**OAKLANDS FARM SOLAR PARK**

**RESPONSE TO DEADLINE 1: WRITTEN REPRESENTATIONS**

**LEICESTERSHIRE COUNTY COUNCIL  
(IP REF NO 20048197)**

**AUGUST 2024**

DRAWING NUMBER DWG/3299/001	REV A
---------------------------------------	----------

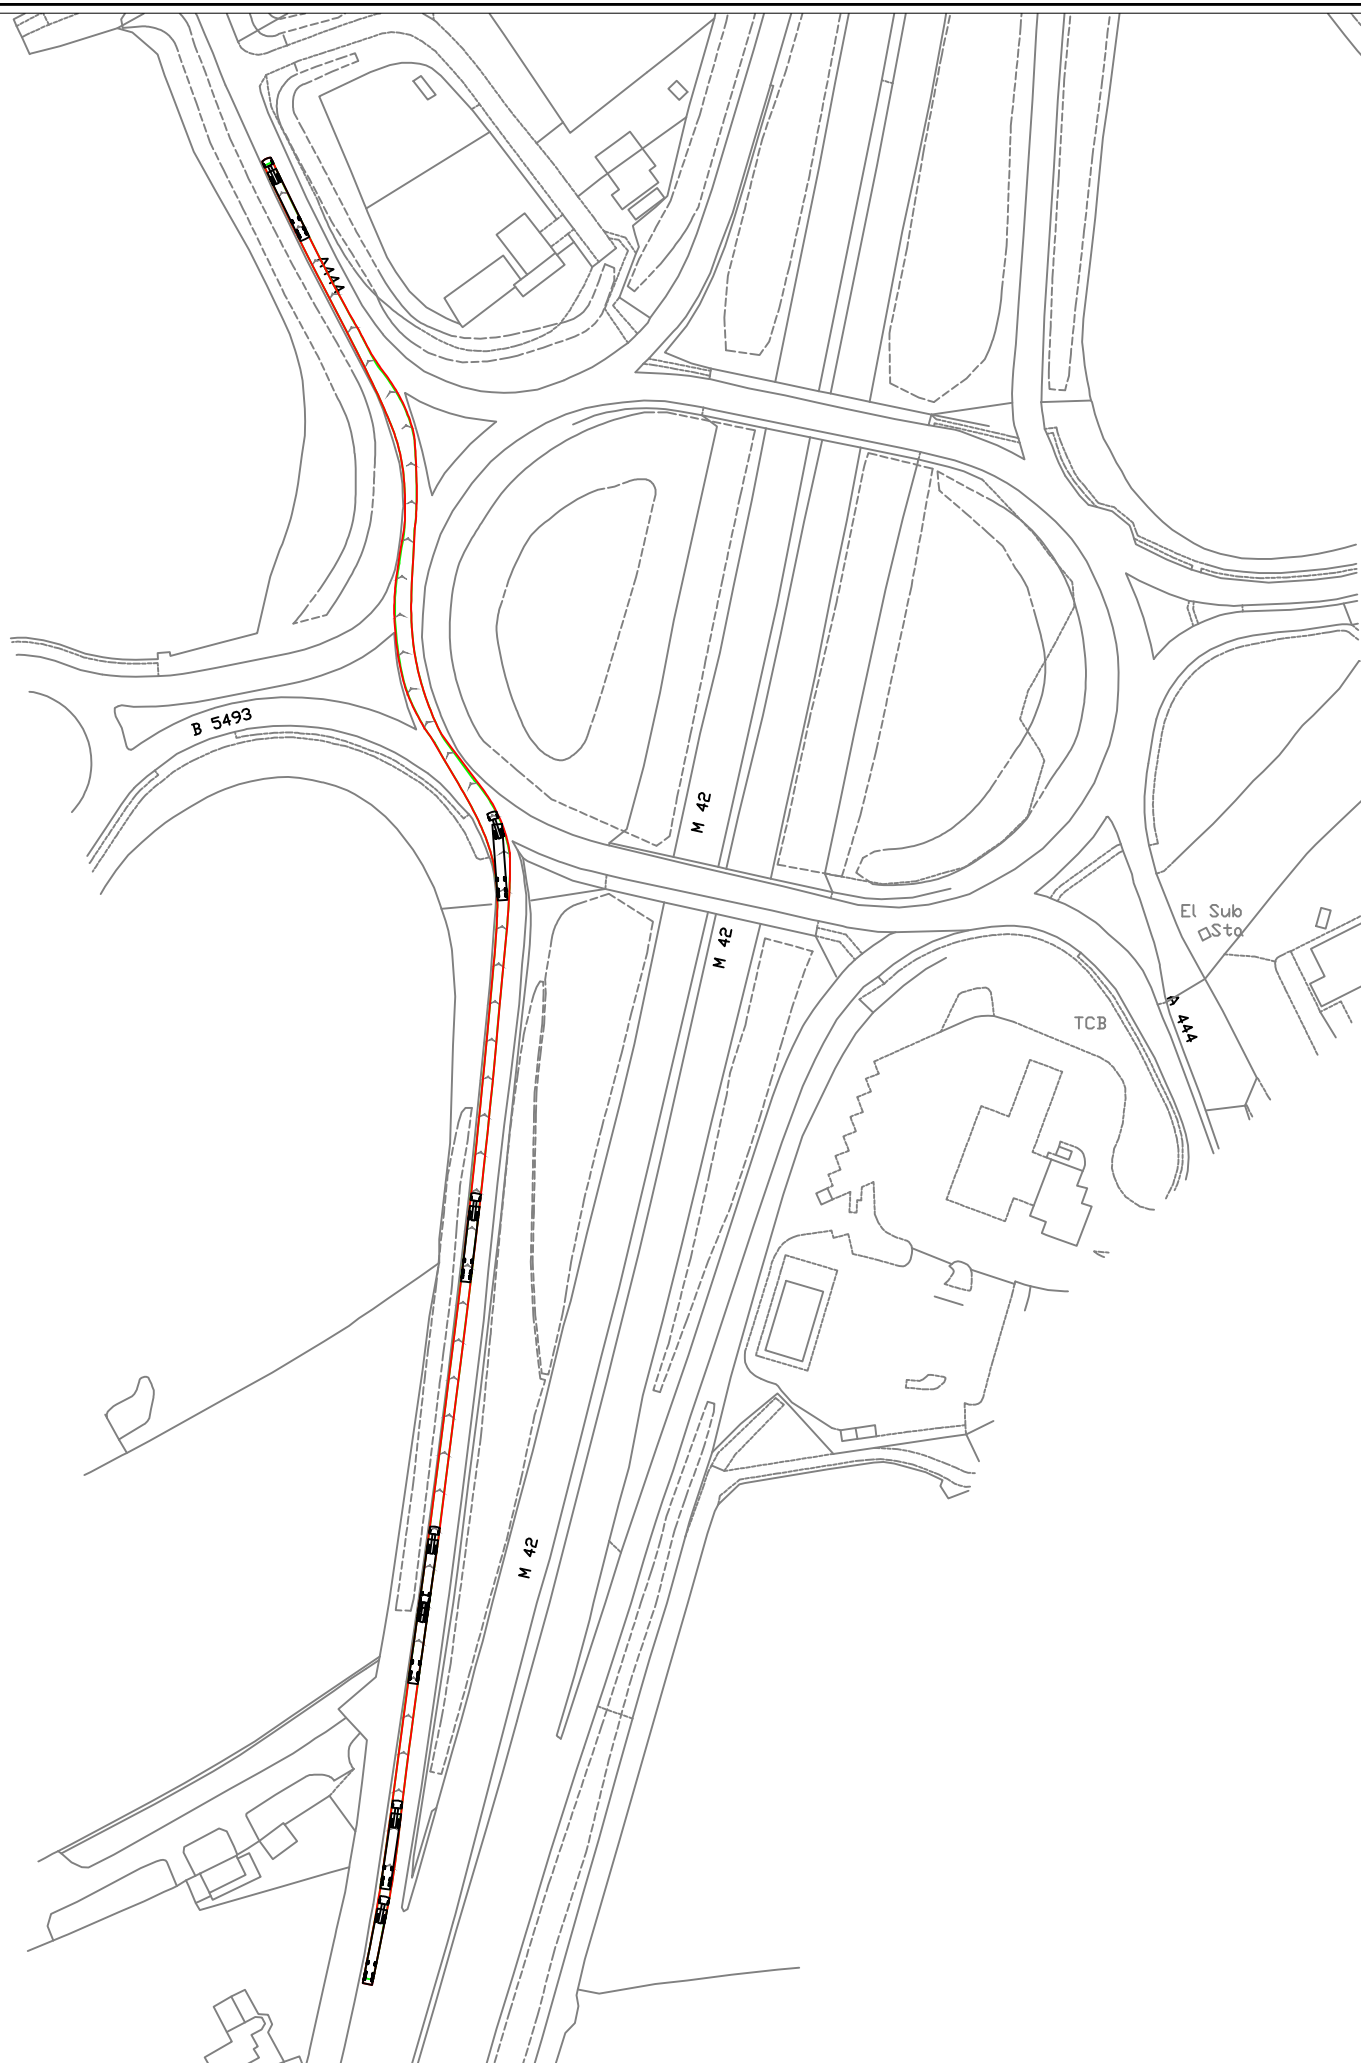
- 2.3 However, the extent and location of such work within the public highway in Leicestershire is unclear. The supporting swept path analysis (APP-154) of which drawing numbers DWG/3299/001 - DWG/3299/005 are relevant to Leicestershire, is labelled as indicative and includes a drawing note which simply states, '*specific vehicle configuration to be checked by specialist haulage company*'. Furthermore, the drawings do not appear to be based on a topographical survey and therefore don't identify street furniture etc; neither do they indicate locations of structures e.g., culverts.

- 2.4 LCC therefore request that the Applicant engages at the earliest opportunity within this Examination process and confirms the vehicle specification, the associated highway impacts, and the necessary mitigation measures on the LRN in Leicestershire.
- 2.5 The Applicant should be aware that the A444 is a Diversion Route for Unplanned Events (DRUE) on the Strategic Road Network (M42) and consideration should be given when planning and programming abnormal load movements.
- 2.6 LCC seeks protection of its assets and recovery of any associated costs through provisions within the Development Consent Order. The draft as submitted (APP-016) does not appear to contain the necessary provisions. Indeed, no reference is made to Leicestershire.
